National Environmental Health Service Submission Report

EHIS reference: 5989 **Applicant:** Milford Quarries Limited

Location: Clogrennane, Bilboa, Co. Carlow

Type of consultation: rEIAR SID

Figure 5.1: Approximate area assessed for recent residential developments (Source Google Earth)

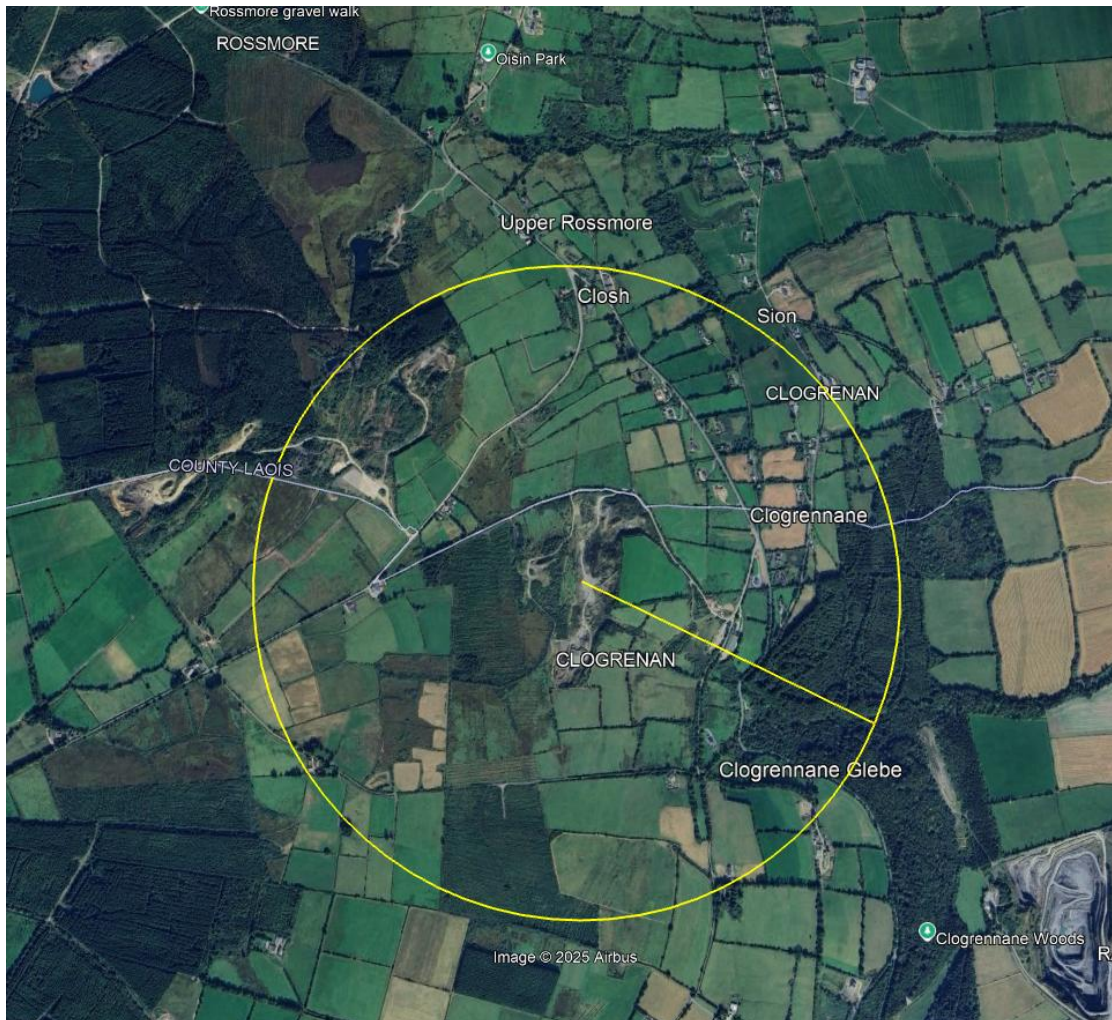
However chapter 5 does not show exactly how near sensitive receptors are in relation to this development i.e. (500m etc.) There is a settlement statement in relation to census and new builds in the area however definitive locations of the closest sensitive receptors; and the possible effects on same were not explored in this chapter and require further analysis.

This data is only available in Nosie chapter which does define locations however it should be fully evaluated within the population health chapter as part of the rEiAR.
